RECORD OF PRE-DEVELOPMENT ADVICE

Mingara Recreation Club Seniors Housing, Tumby Umbi (SSD-63475709) – Council Submission

I refer to your email of 20 December 2024 where a time extension was granted until 10 January 2025 for Council to provide the following comments on the exhibited development.

WATER INFRASTRUCTURE

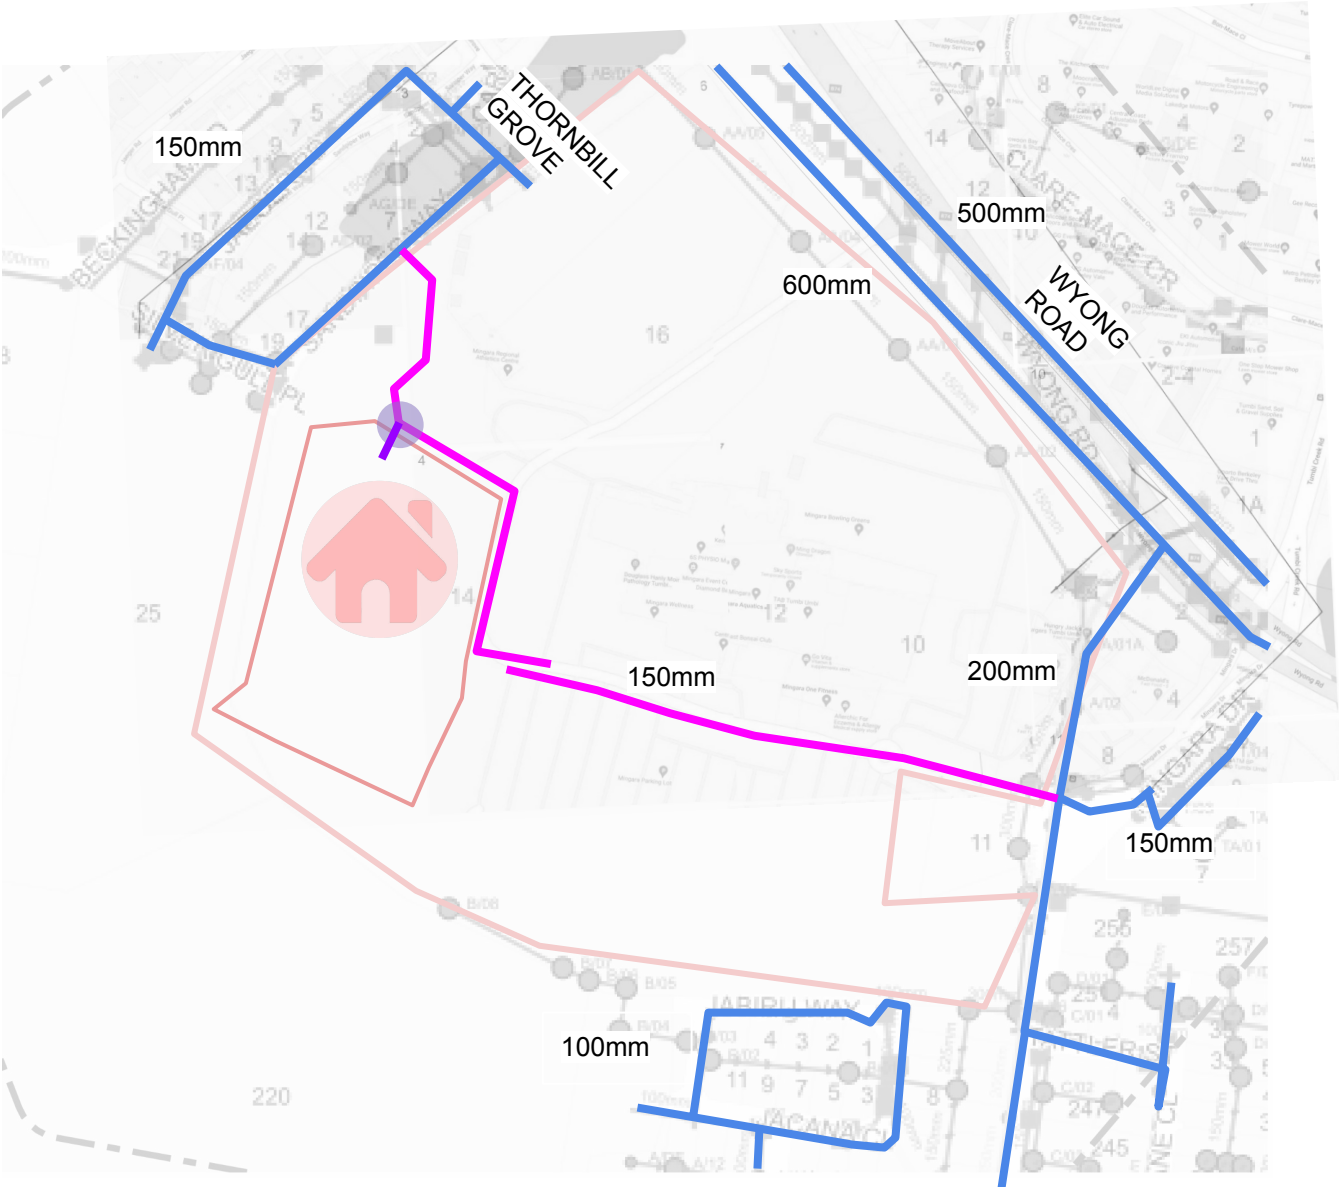
Water and sewer services are available to the land, but based on initial investigations there is insufficient water and sewer reticulated main capacity to adequately service this pre development proposal.

As such this proposal is not currently supported by Water and Sewer until it can be demonstrated that the proposal can be adequately serviced with Water and Sewer. A water and sewer servicing plan is to be prepared and provided including point of connection to Council mains, location of conduits between Council mains and the proposed consolidated lot, easements for services. Once received, further feedback can be provided.

Figure 3: Proposed Development Masterplan

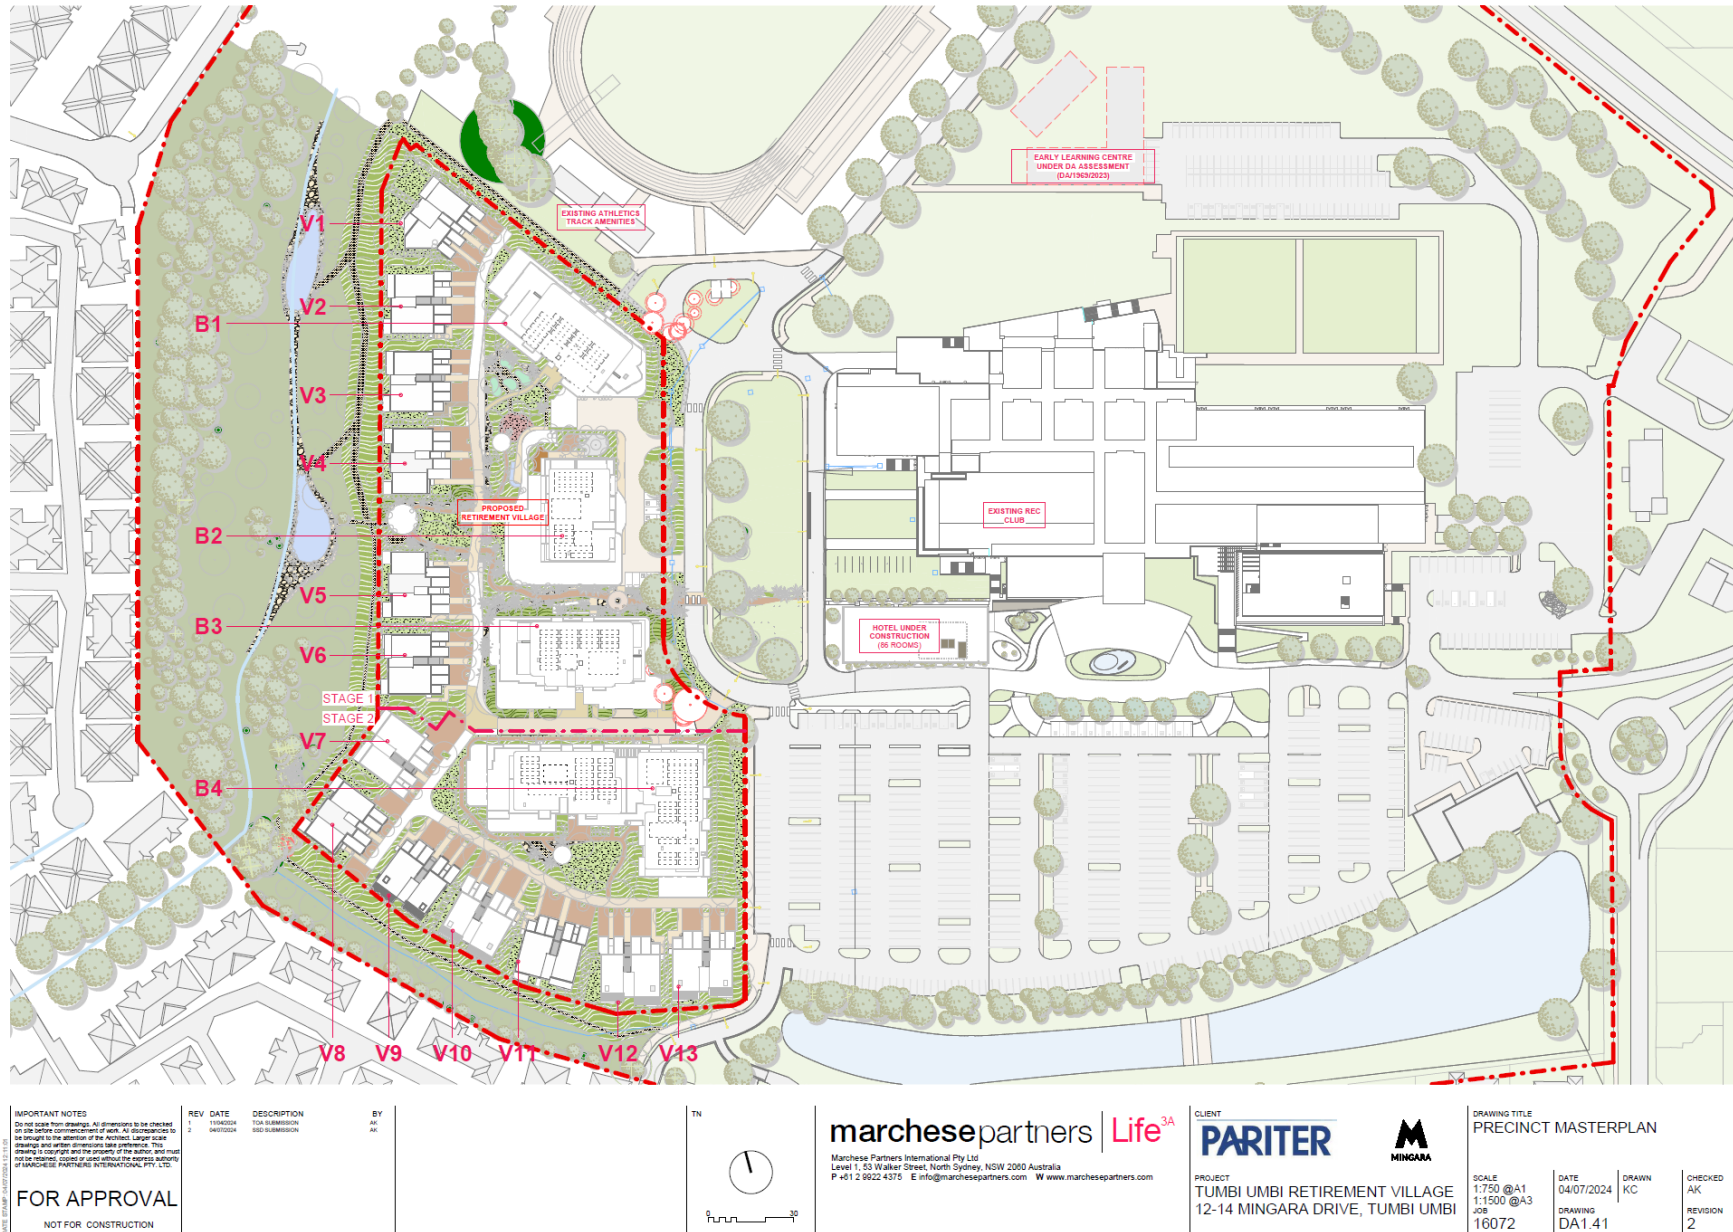
Council previously advised in the pre-lodgement meeting with the applicant that a masterplan for the site should be prepared given the size, scale and density proposed in the seniors living development especially given there is no public road access. No masterplan has been prepared.

Figure 3-1. Riparian restoration plan

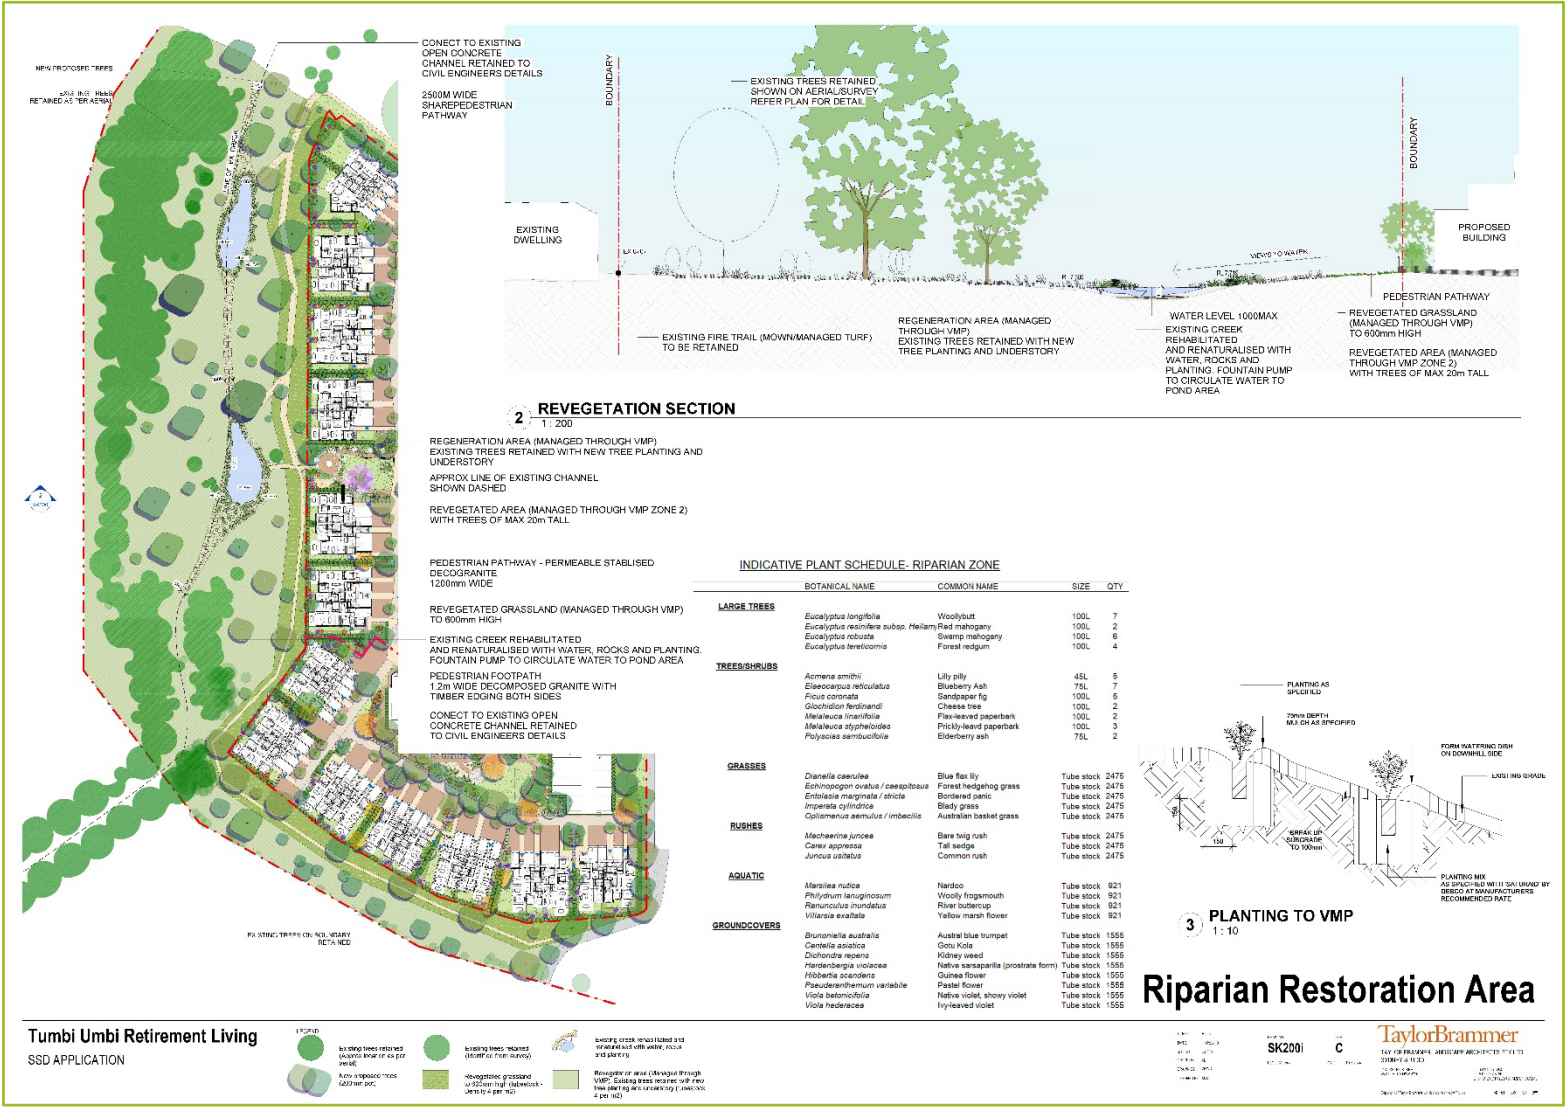
As identified in the riparian restoration area plan provided, a Vegetation Management Plan (VMP) should be prepared for the drainage corridor. Council's [Flora and Fauna Guidelines 2019](#), provide some information on VMP requirements. The VMP should also integrate with NSW DPE Water requirements. Being an SSD, the department will review the VMP with comment usually provided by Council. Items the VMP should address include:

- The VMP area needs to be clearly defined and should encompass most of the drainage corridor adjacent the precinct.
- Identify vegetation management zones, APZs, weed density/other management issues which need to be addressed.
